**STORE PROPERTY INVESTMENTS LTD
LAND WEST OF BROOK LANE AND
SOUTH OF A259
RUSTINGTON**

**ROAD SAFETY AUDIT RESPONSE
REPORT
STAGE 1 - ROAD SAFETY AUDIT**

JUNE 2018

scale	1:500@A3	drawn by	OAN	checked by	VL
date	JUNE 2018	cad file	Master 2018-06-06.DWG		
drawing number	SPRUST(BROOK LANE).1/10				rev.
					A

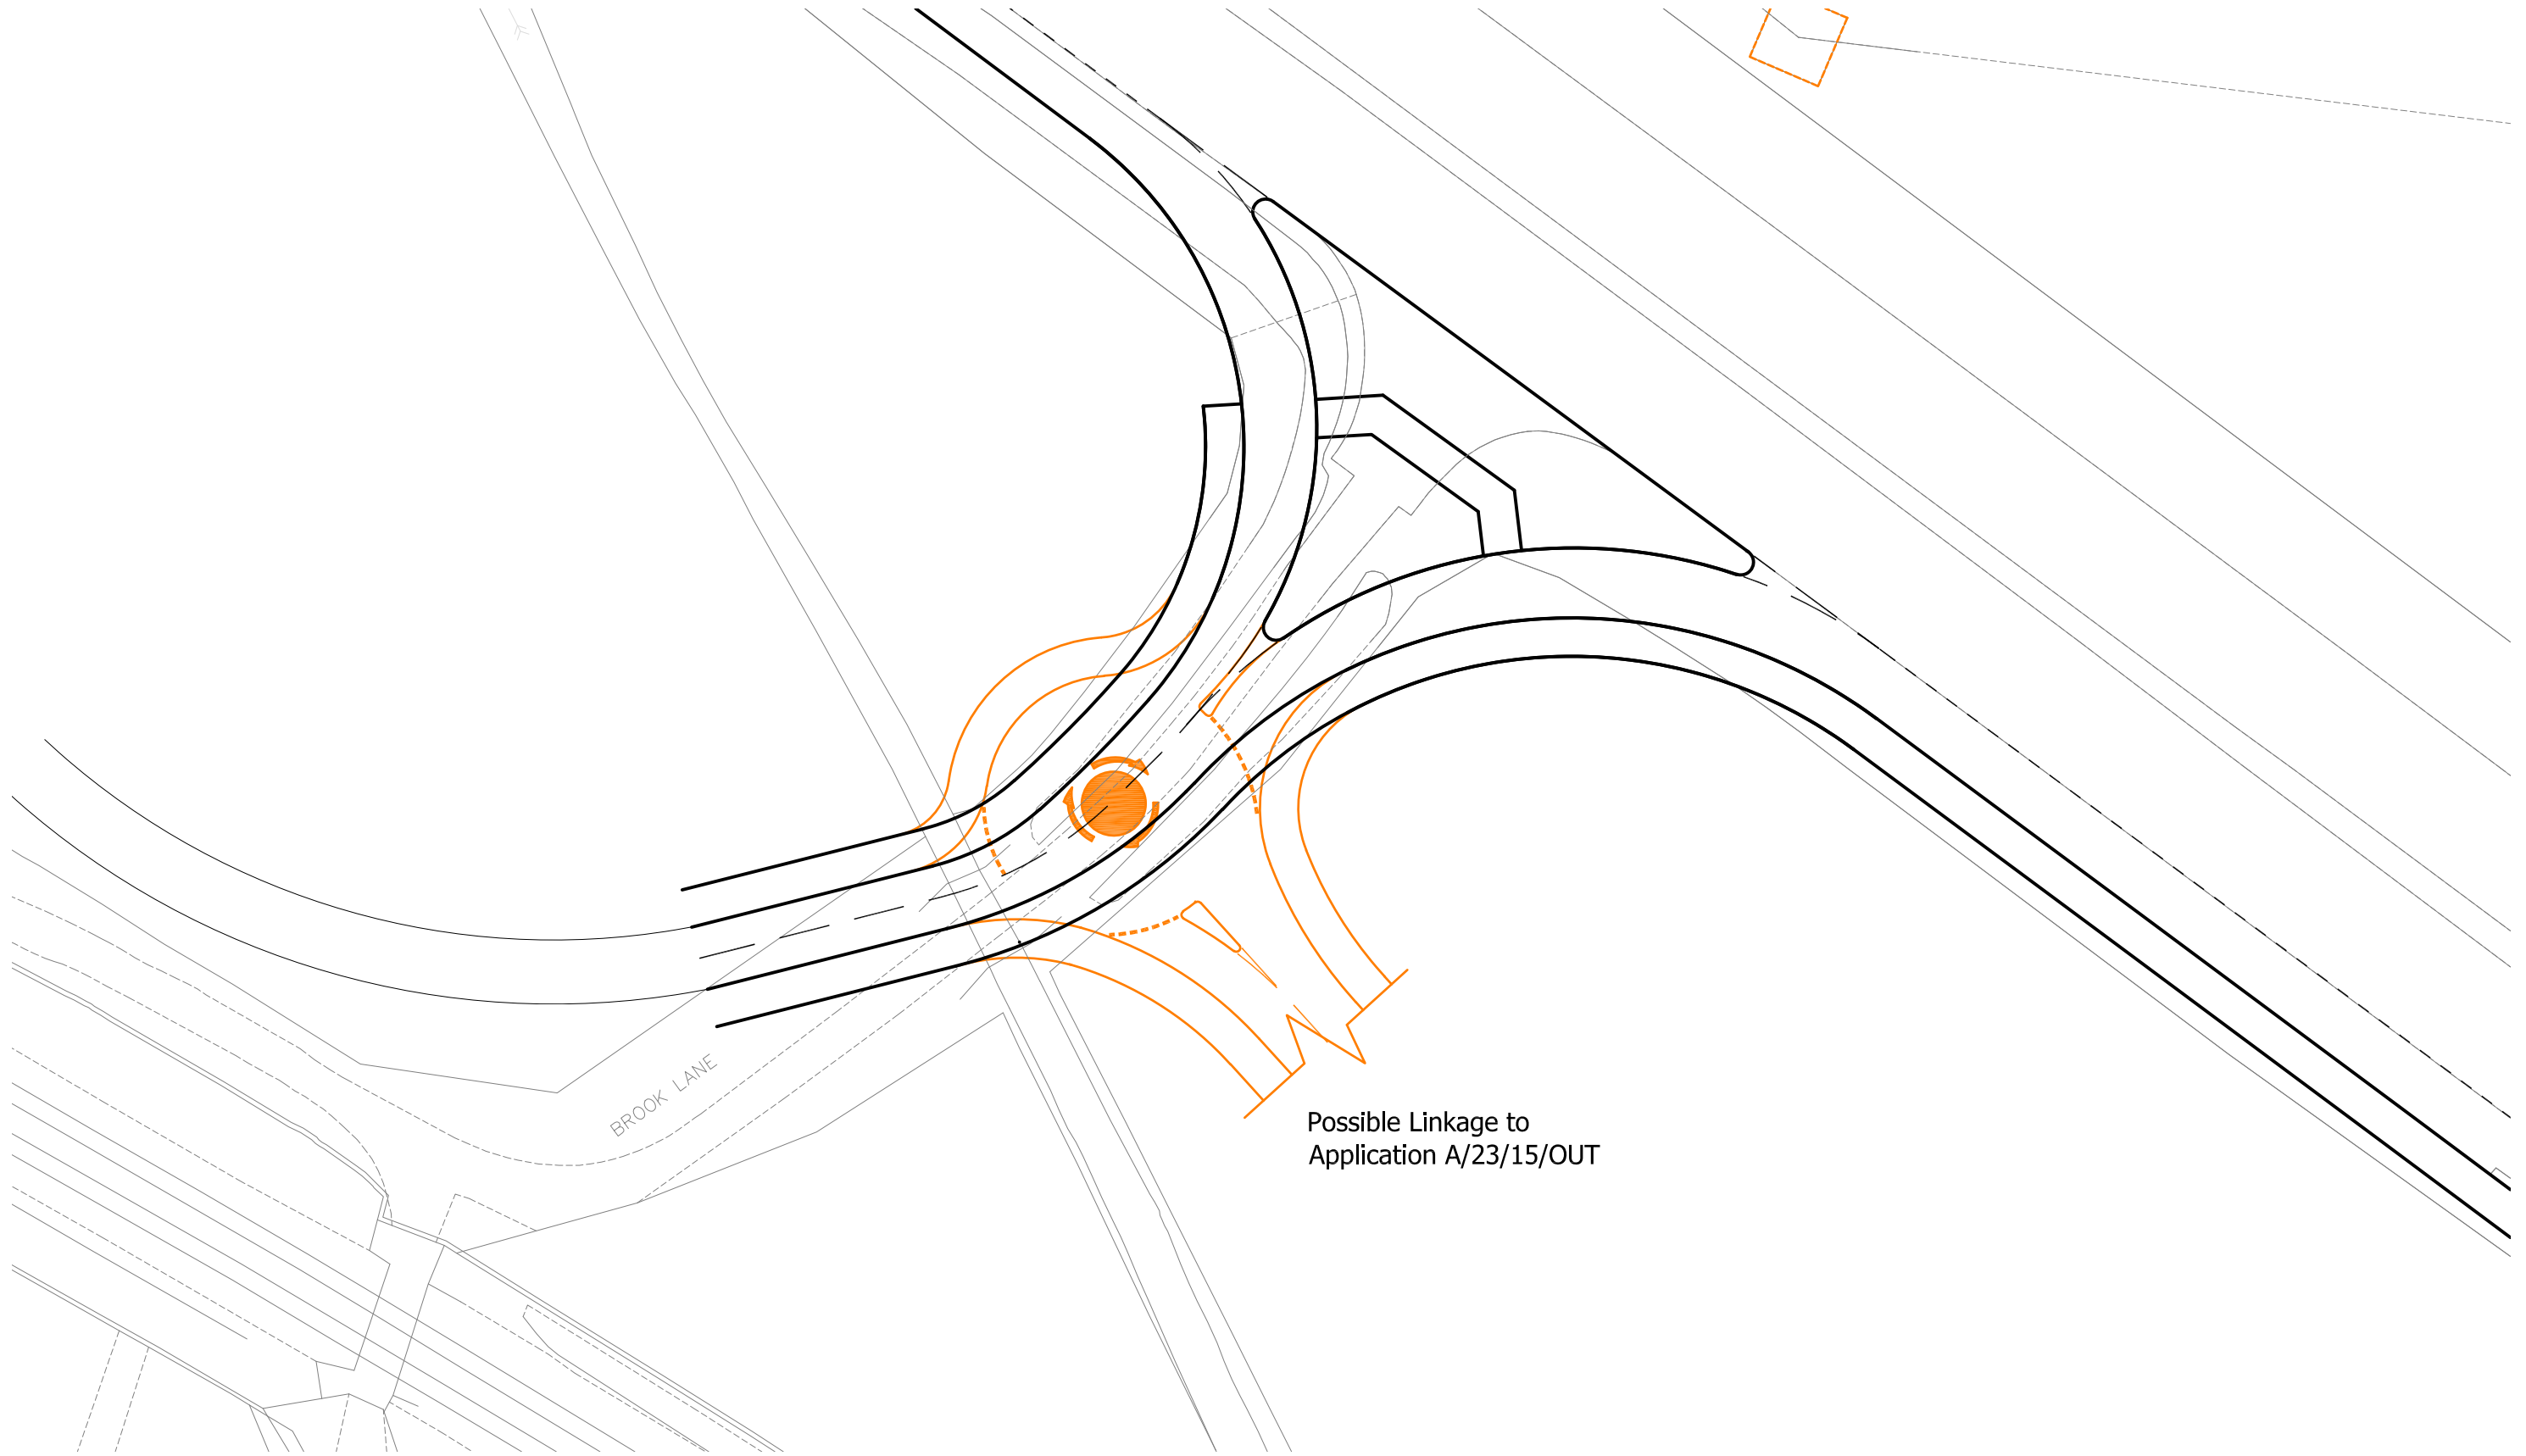
This is agreed, drawing SPRUST(BROOKLANE).1/10A included at **Appendix A** shows a 3m footway/cycleway along the southern side of the A259 linking to the retail developments to the east.

The westbound approach on the A259 to the proposed junction is provided with a margin (circa 1 metre), is delineated by a solid white line. The proposed northern kerb line of the proposed traffic island does not benefit from a margin. This could result in vehicles striking the kerb and subsequently losing control.

Offset the northern kerb line southwards to provide an appropriate margin.

This is agreed, drawing SPRUST(BROOKLANE).1/10B included at **Appendix D** shows a revised kerb line to include a 1m margin.

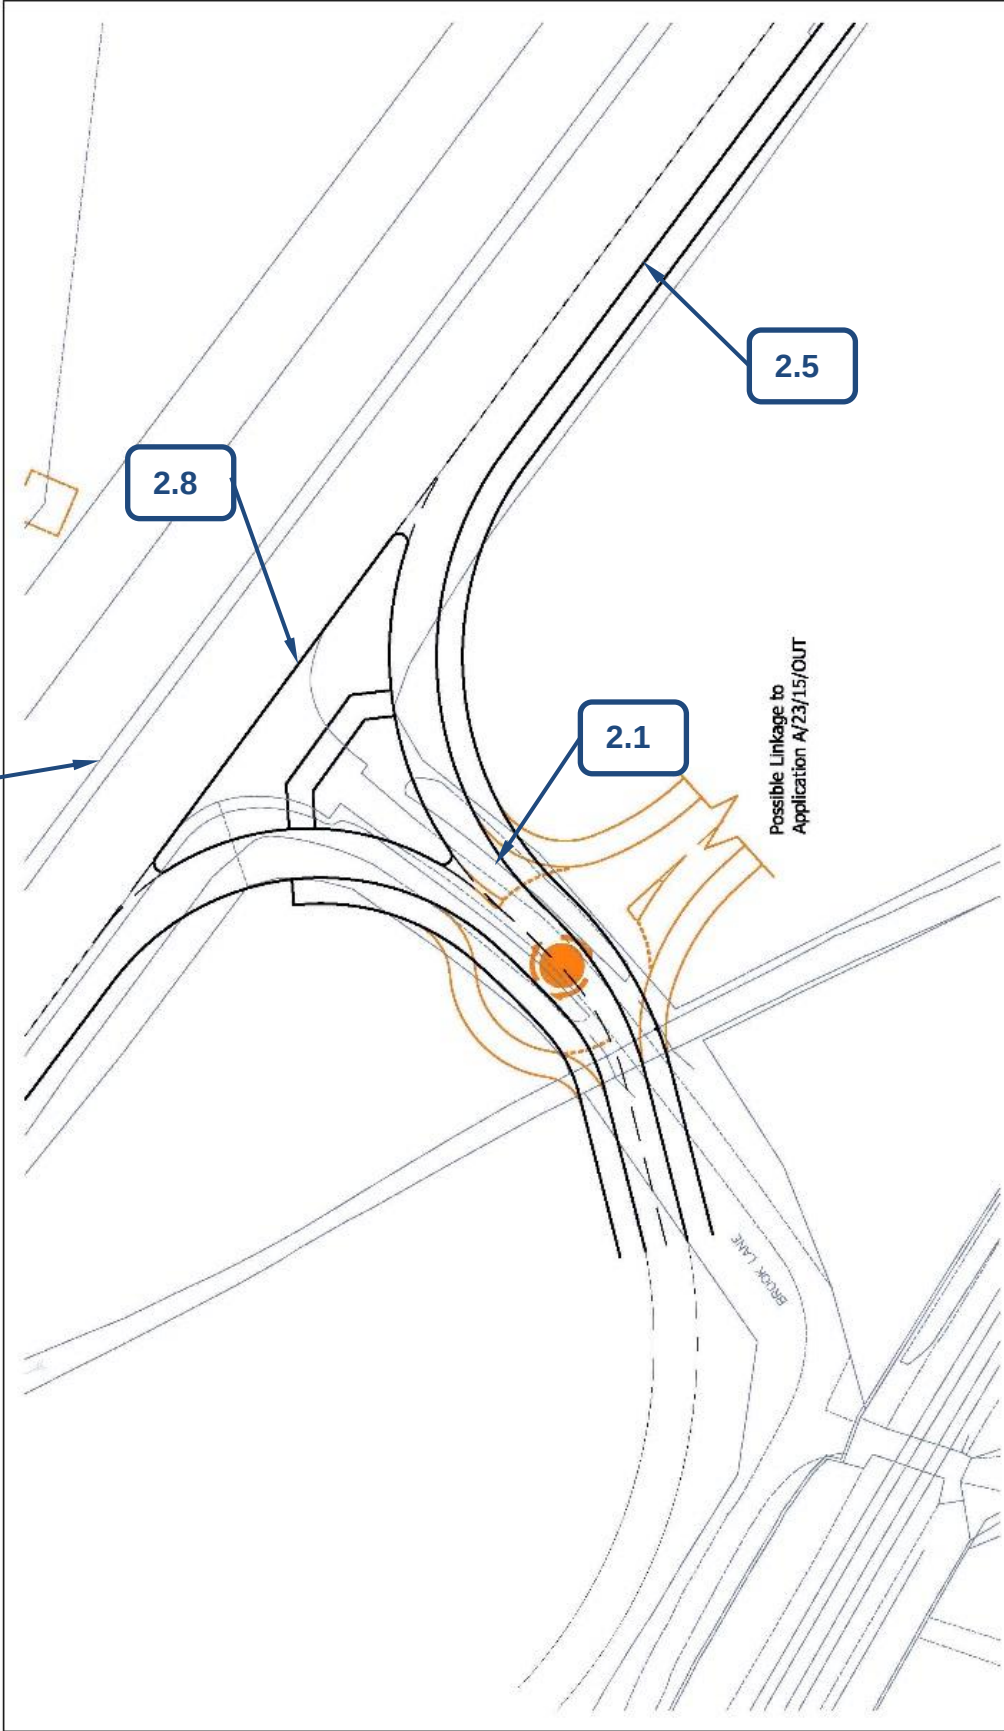
Location: Proposed mini-roundabout southbound approach

Summary: Potential queuing at mini roundabout – rear end type collisions

The Audit Team are satisfied with the general arrangement of the proposed traffic mini-roundabout junction and that there is likely to be minimal traffic approaching from the south and turning east into the other site, resulting in southbound traffic waiting and giving way.

However, it is important to ensure that there is sufficient capacity for the type and volume of traffic this development site will generate. Waiting traffic could tail back from stop line and obstruct westbound through lane of the A259 with consequence risk of tail end collisions.

Ensure that the southbound approach lane provides sufficient capacity for anticipated vehicles entering the proposed development site and the site located to the east.

There is an existing sign (diag 562) located on the westbound approach to the proposed junction. This sign may need to be relocated as appears that it is currently sited on the verge that will either form part of the deceleration lane for the proposed junction or the proposed footway.

Relocate sign and sign posts.

The proposed junction is located on a dual carriageway section of the westbound A259, it is therefore important that drivers leaving the development site turn left to join the westbound traffic flow.

Provide appropriate signing on the central reserve to ensure that vehicles turn left when egressing the development site.

This is agreed, the roundabout has been assessed used using the ARCADY programme within the Junctions 9 software. The results show that no vehicles will queue on the A259 approach. A copy of the ARCADY output file is included at **Appendix B**.

This is agreed, signage will be addressed at the detailed design stage.

This is agreed, signage will be addressed at the detailed design stage
